2024/0679

16 Bell Bank View, Worsbrough, Barnsley, S70 5HS

Re-build existing wall with 1-metre-high wall with 1.4-metre-high pillars and wrought iron infill.

BLOCK PLAN

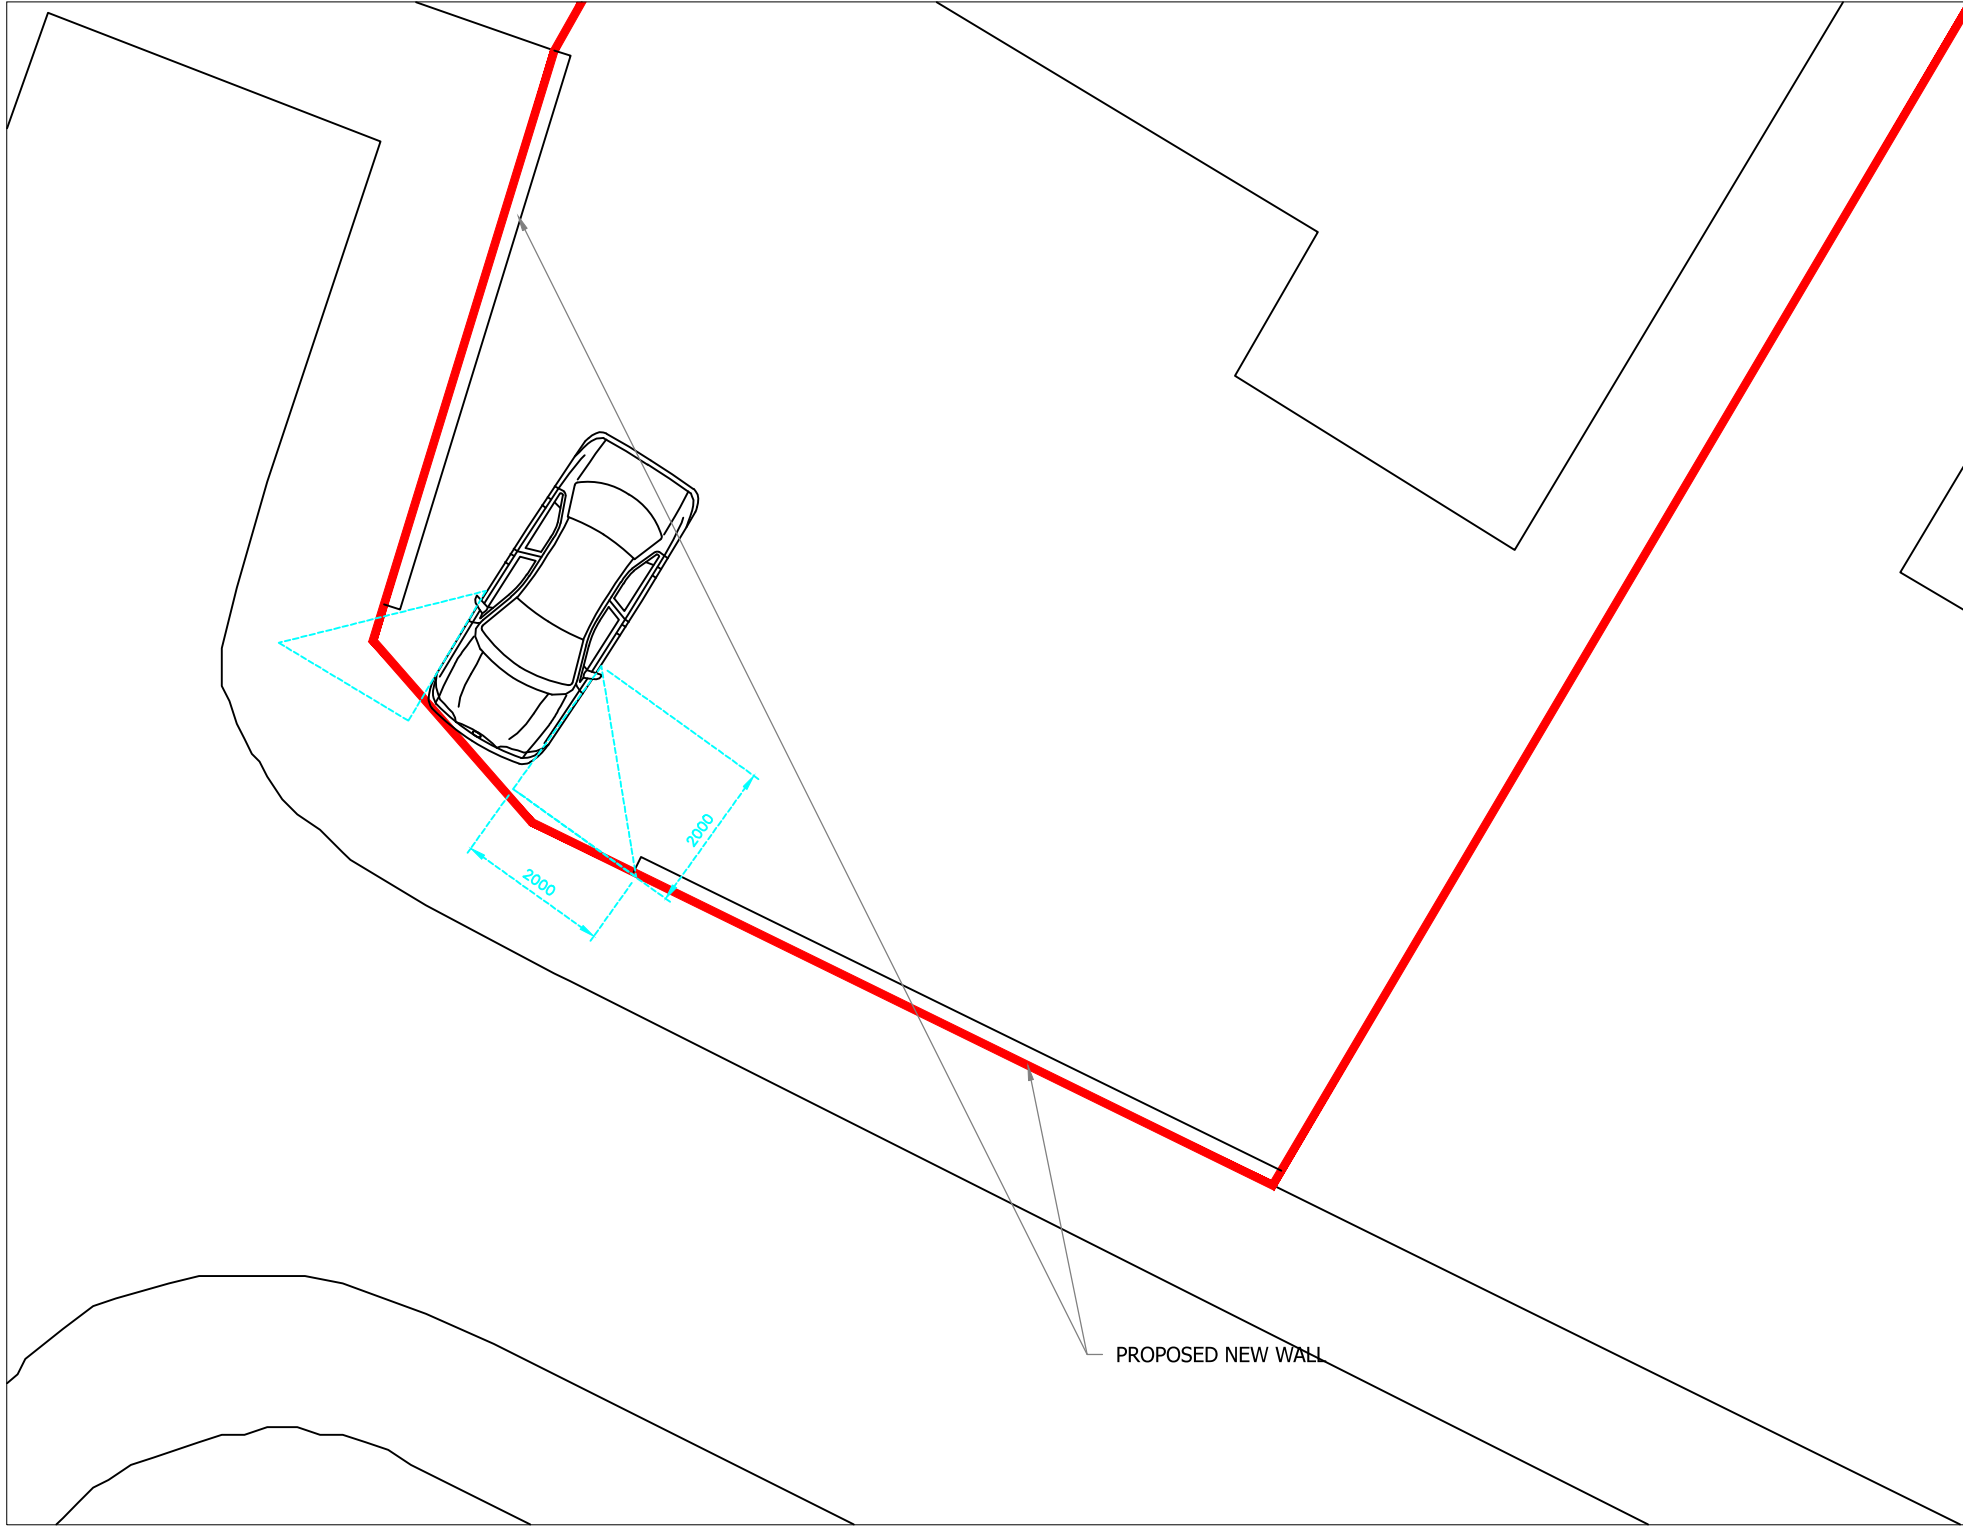
The proposal would result in increase in the wall height to an approximate total height of 1.4 metres. Highways have provided objection to this height increase due to a detrimental impact on highway safety. A height of 1.4 metres does not provide sufficient visibility for drivers leaving the property and therefore an unacceptable impact on highway safety. The importance of this element is further impacted by the turning head to the southwest of the site which is entered directly via the driveway access. Furthermore, the proposed height impacts the visibility of the driveway at neighbouring 16 and 18 Bell Bank View providing further loss to highway visibility, impacting upon highway safety.

PROPOSED ELEVATIONS

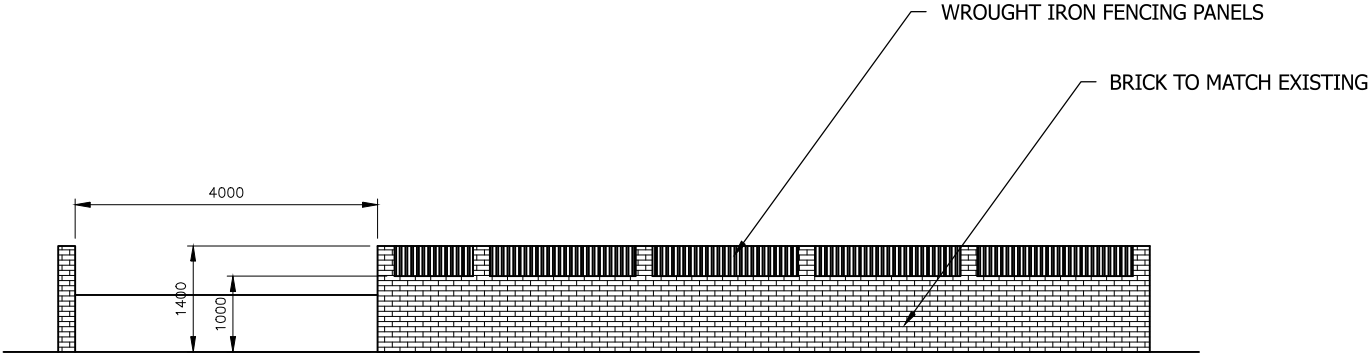
Highways – Objection due to the height of the wall not allowing for acceptable levels of driver visibility when leaving the site and is further compounded by the existing turning head to the southwest.

The initial proposal providing pillar heights of approximately 1.8 metres was considered too dominant on the street scene and did not align with any other front boundary walls on the street scene. A reduction to approximately 1.4 metre high pillars was welcomed and considered more acceptable.
